RFS

Your reference: SSD-71547218
Our reference: DA20240613002390-Response to
Submissions-1

**State Significant Development – Response to Submissions – Waste or resource management facility
1, 8 & 10 Styles Street & 145, 147 Mitchell Avenue Kurri Kurri NSW 2327, 3//DP586741, 1//DP1128108,
4//DP586741, 6//DP1251190, 1//DP1309128**

The NSW Rural Fire Service (RFS) has reviewed the *Kurri Kurri Integrated Resource Recovery Centre Response to Submissions Report* (Central Waste Plant Pty Ltd), prepared by EMM Consulting Pty Ltd (Alexandra Bishop, March 2026), including Appendix F (Report titled: *Updated Bushfire Consultant Response to RFS Submission*, prepared by Cool Burn Pty Ltd. Ref J317, dated 16 March 2026).

Weighbridge Shed - East Elevation  
Scale: 1 : 100

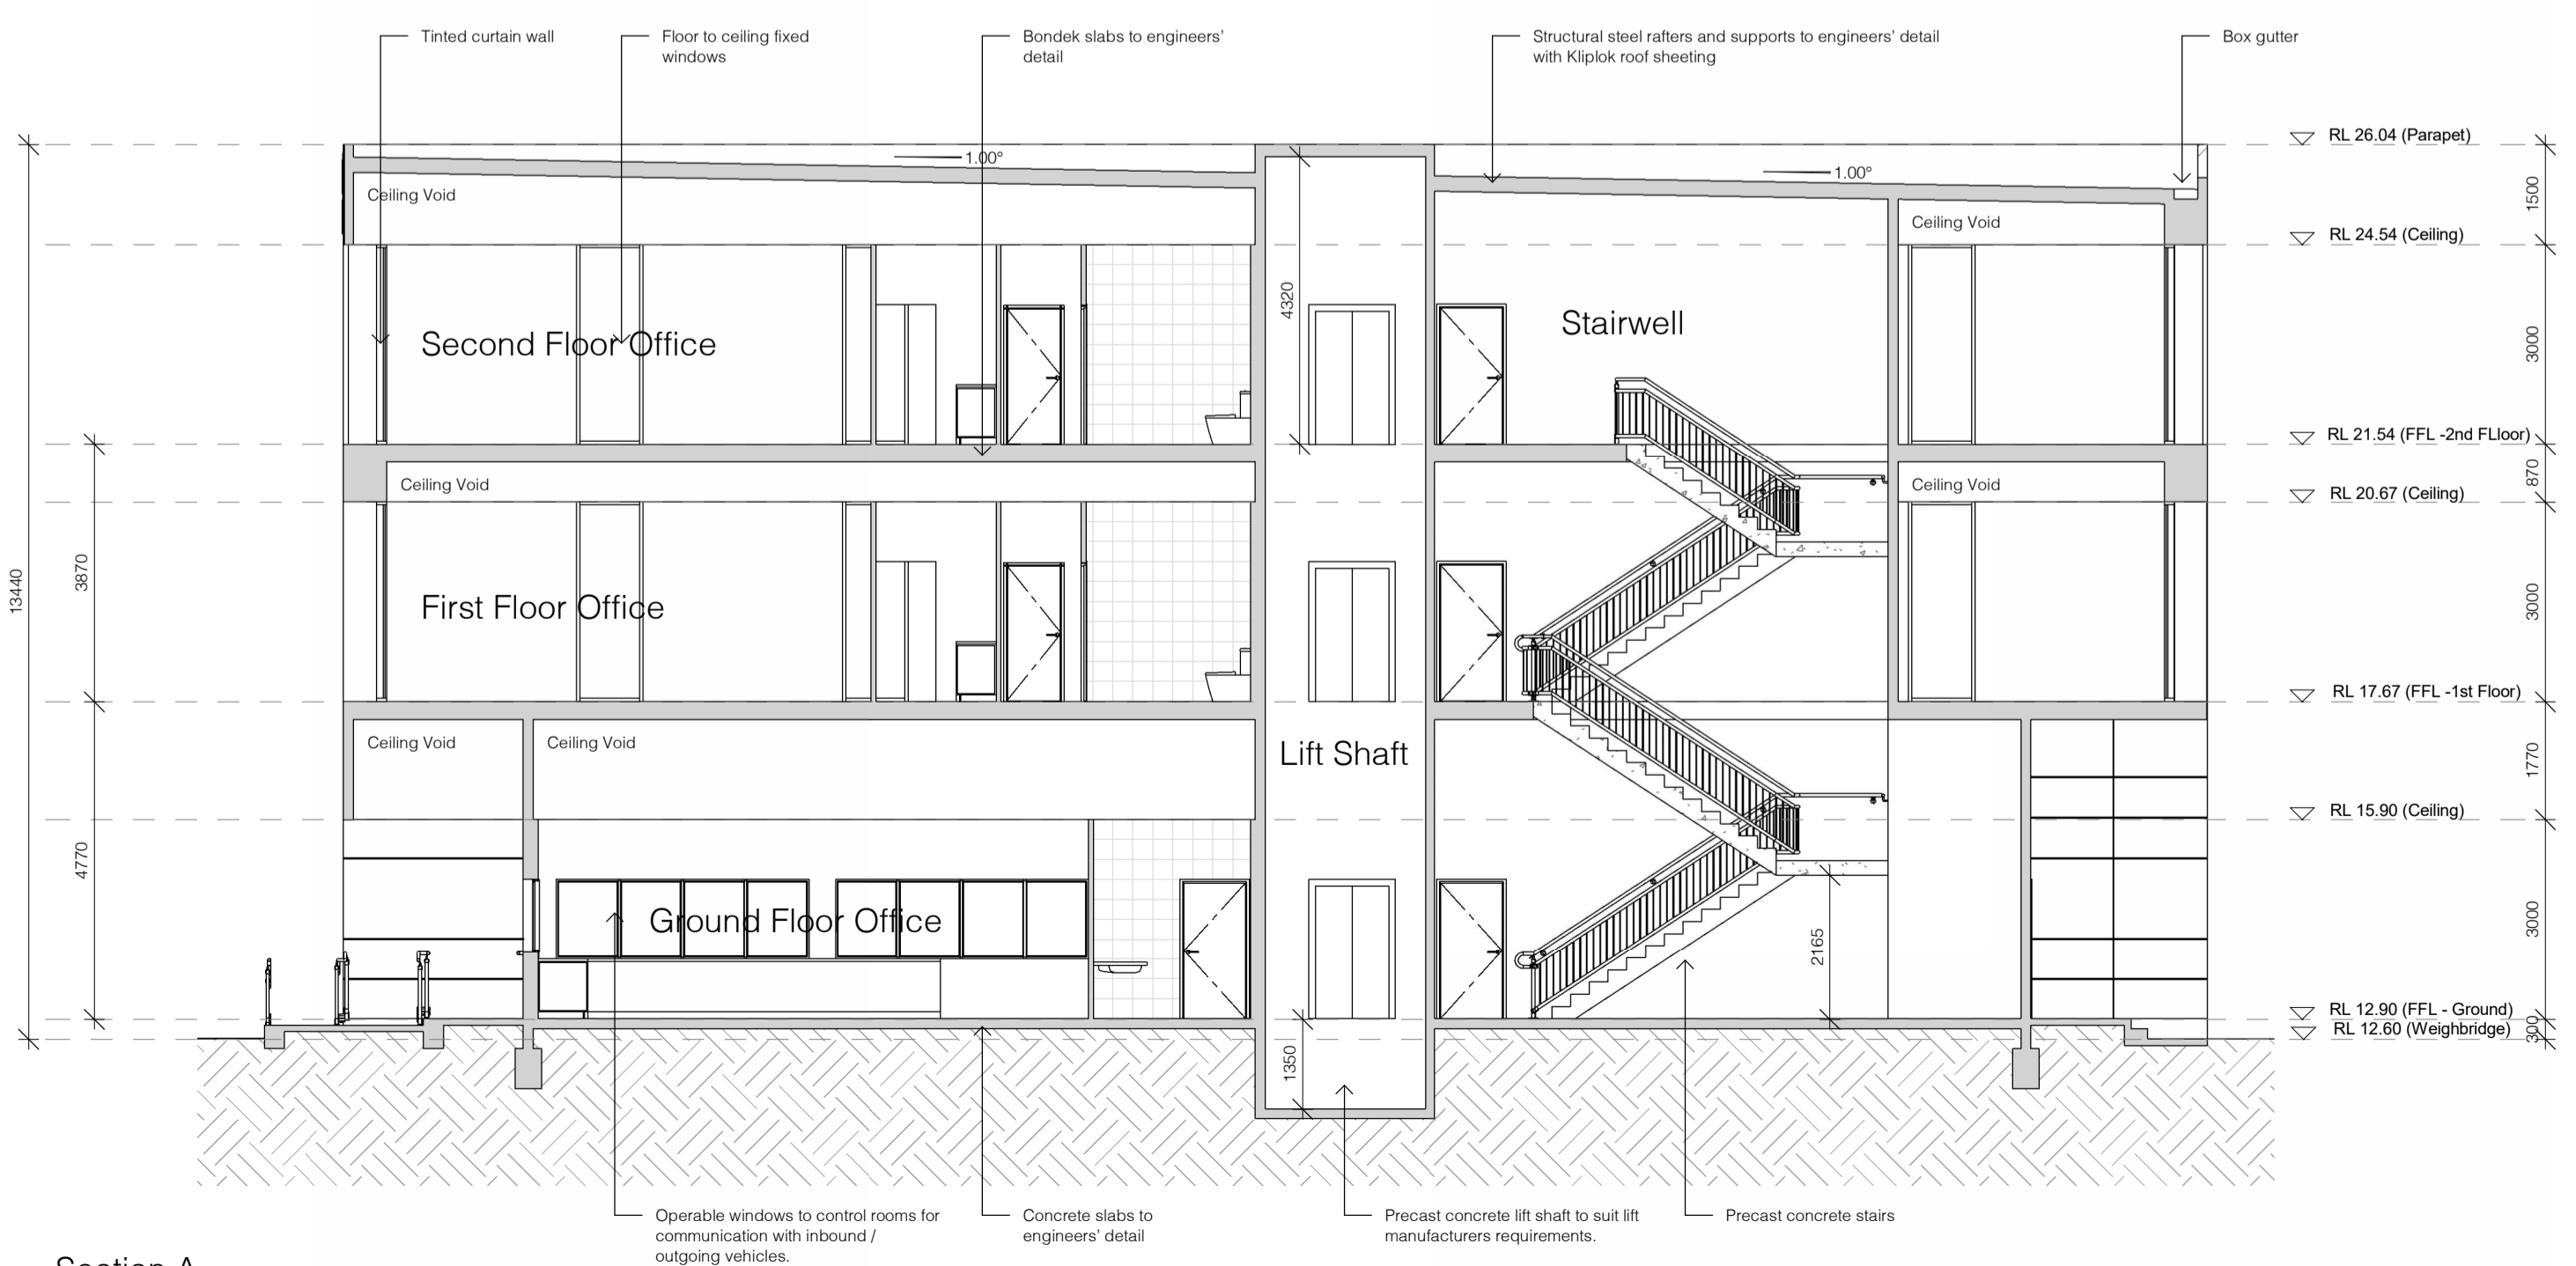
4. The proposed offices located above the weighbridge, must be upgraded to improve ember protection by enclosing all openings (excluding roof tile spaces) or covering openings with a non-corrosive metal screen mesh with a maximum aperture of 2mm. Where applicable, this includes any sub floor areas, openable windows, vents, weepholes and eaves. External doors are to be fitted with draft excluders.

Residual Material Processing Shed - Ground Floor Plan  
Scale: 1 : 200

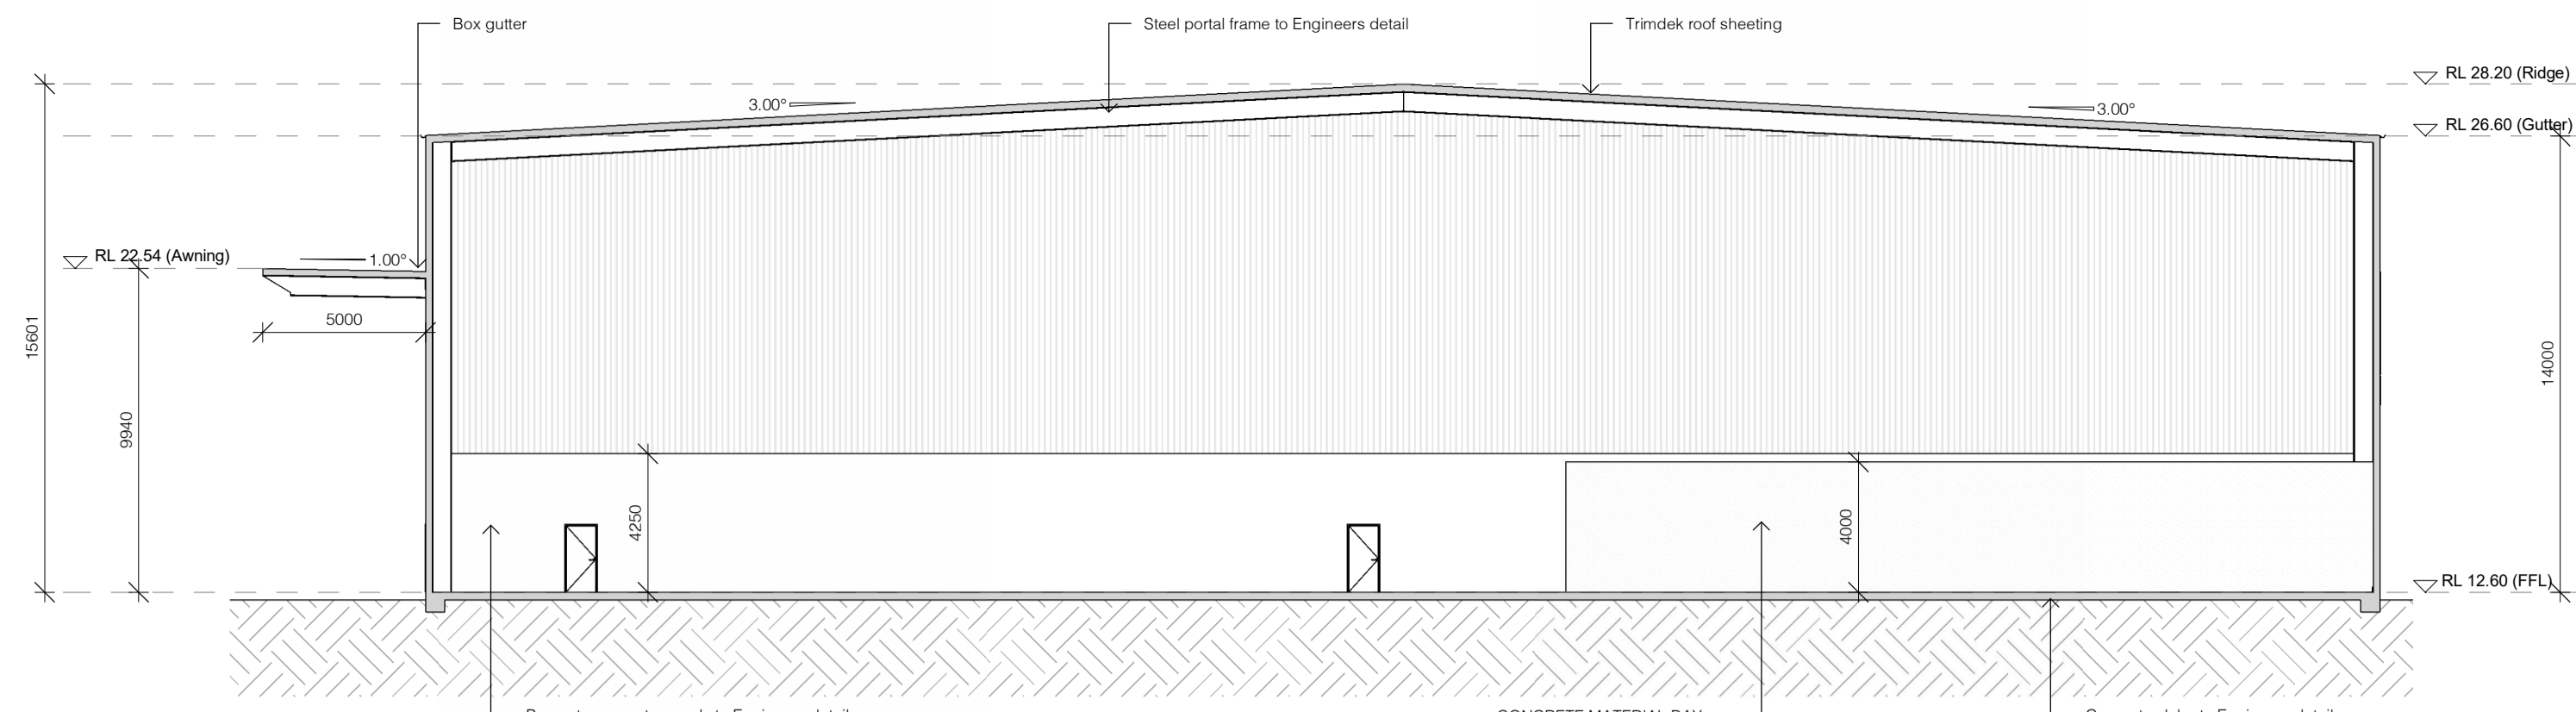
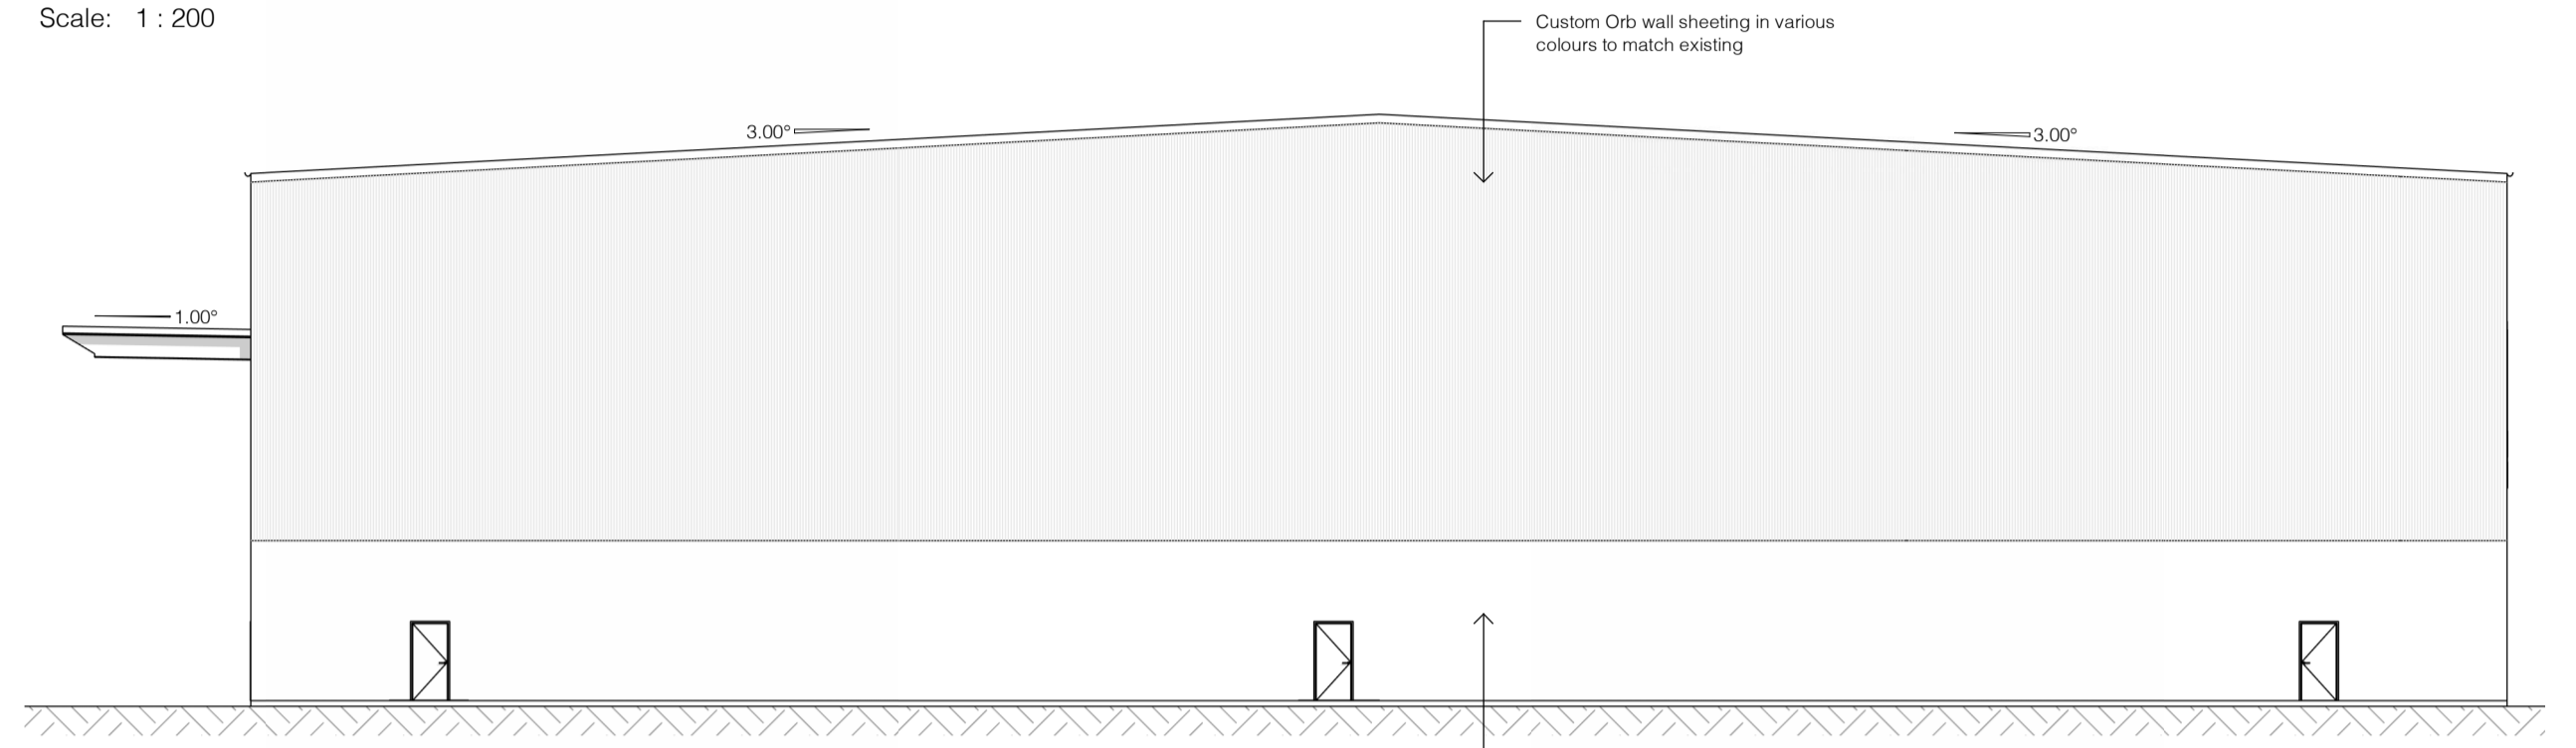
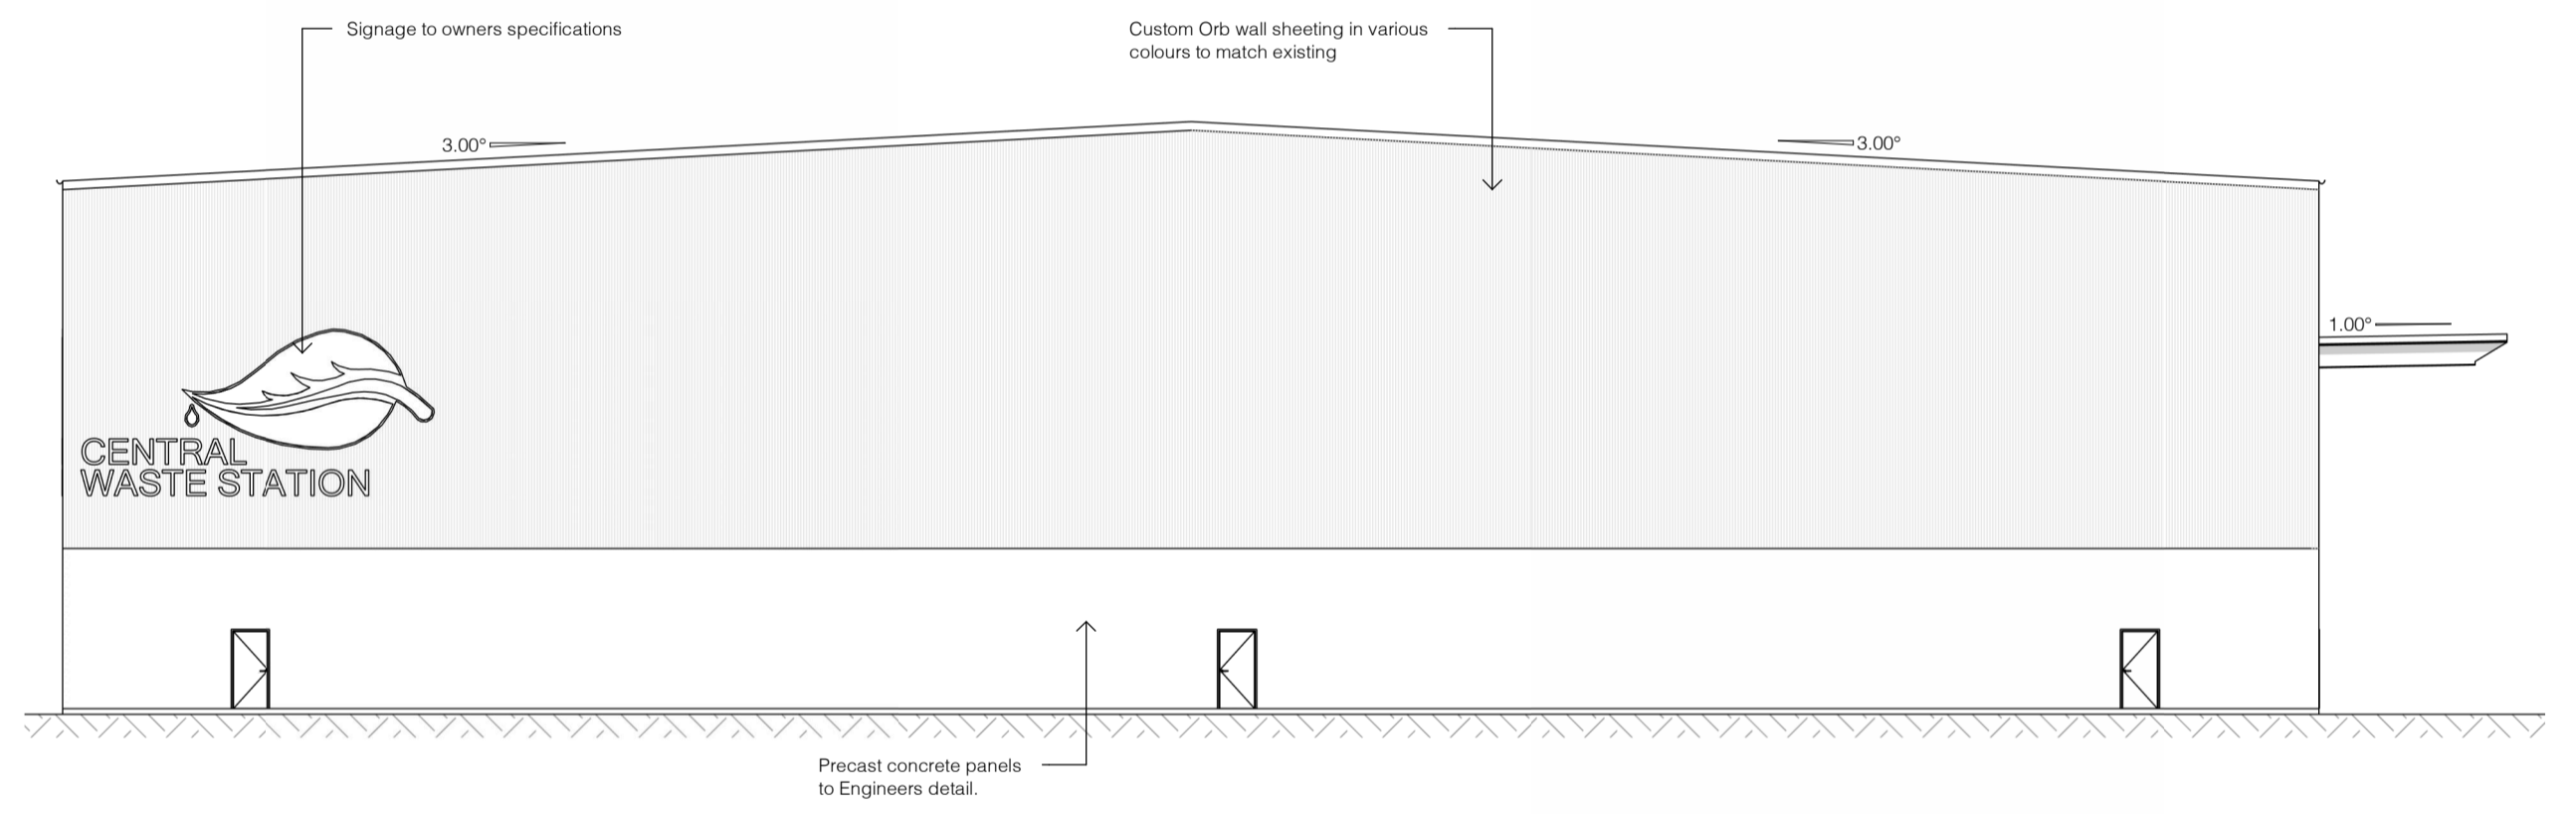
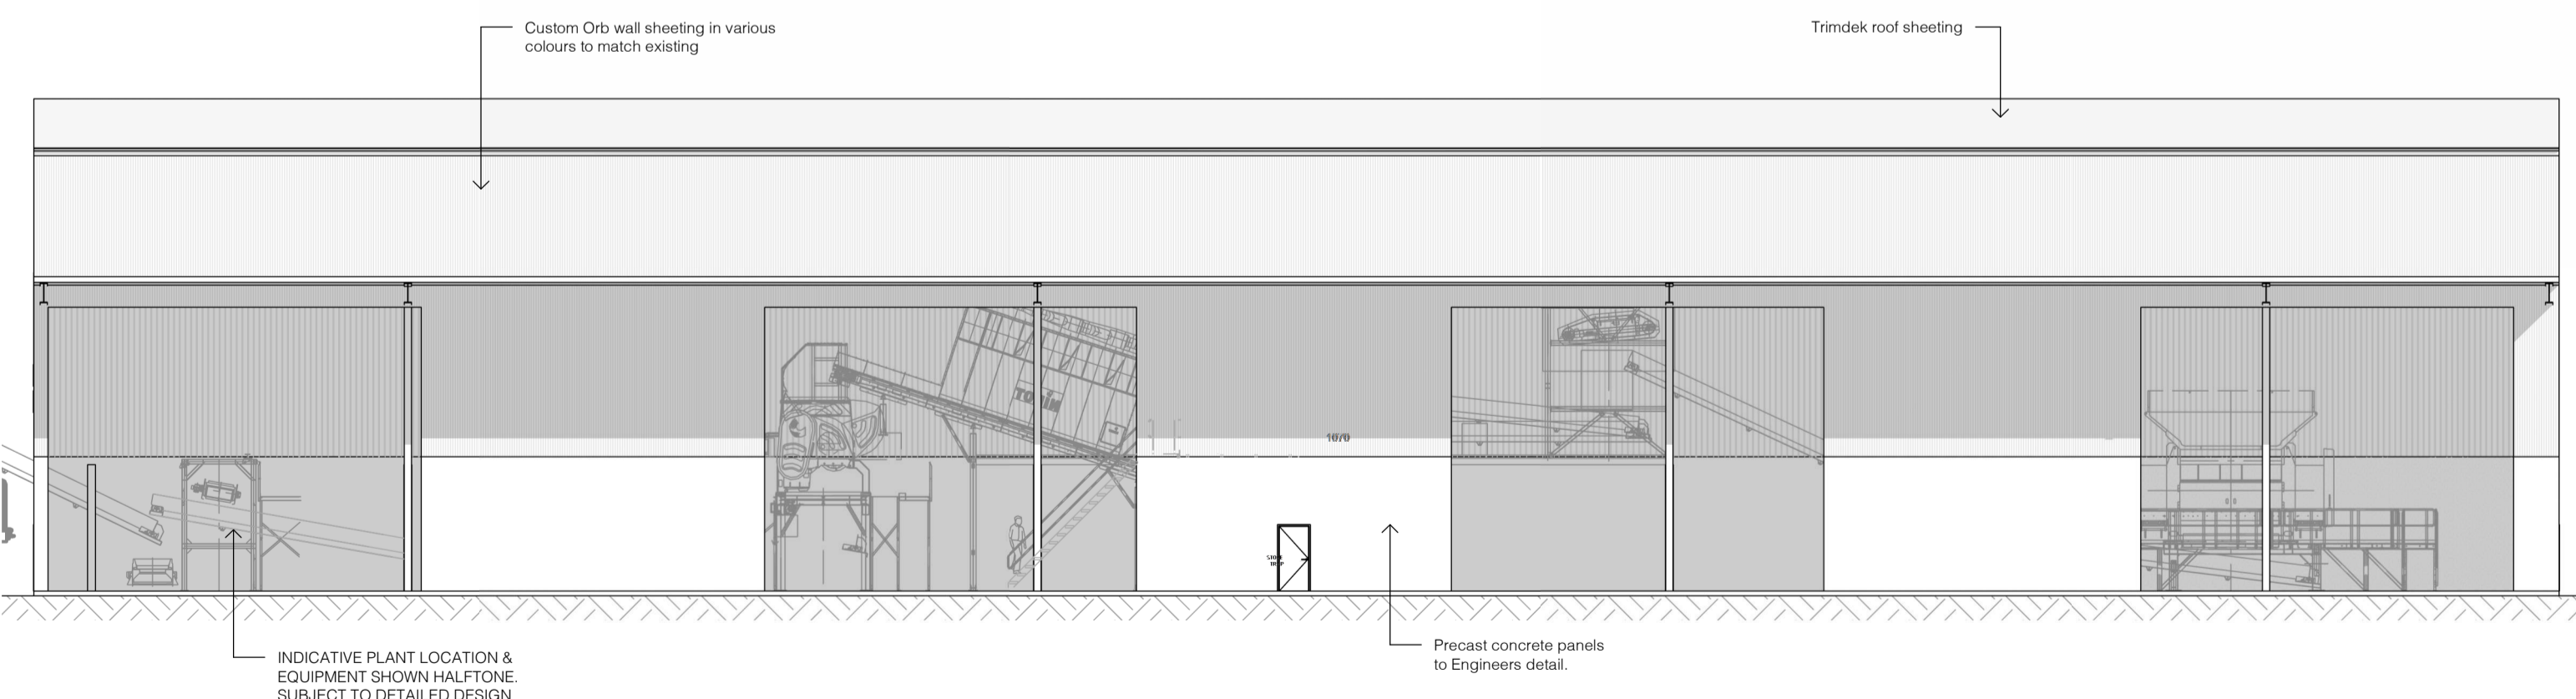
3. Proposed construction of the awnings, located over existing storage sheds, new processing shed additions (material bays) and the residual materials processing shed, must be undertaken using non-combustible materials.
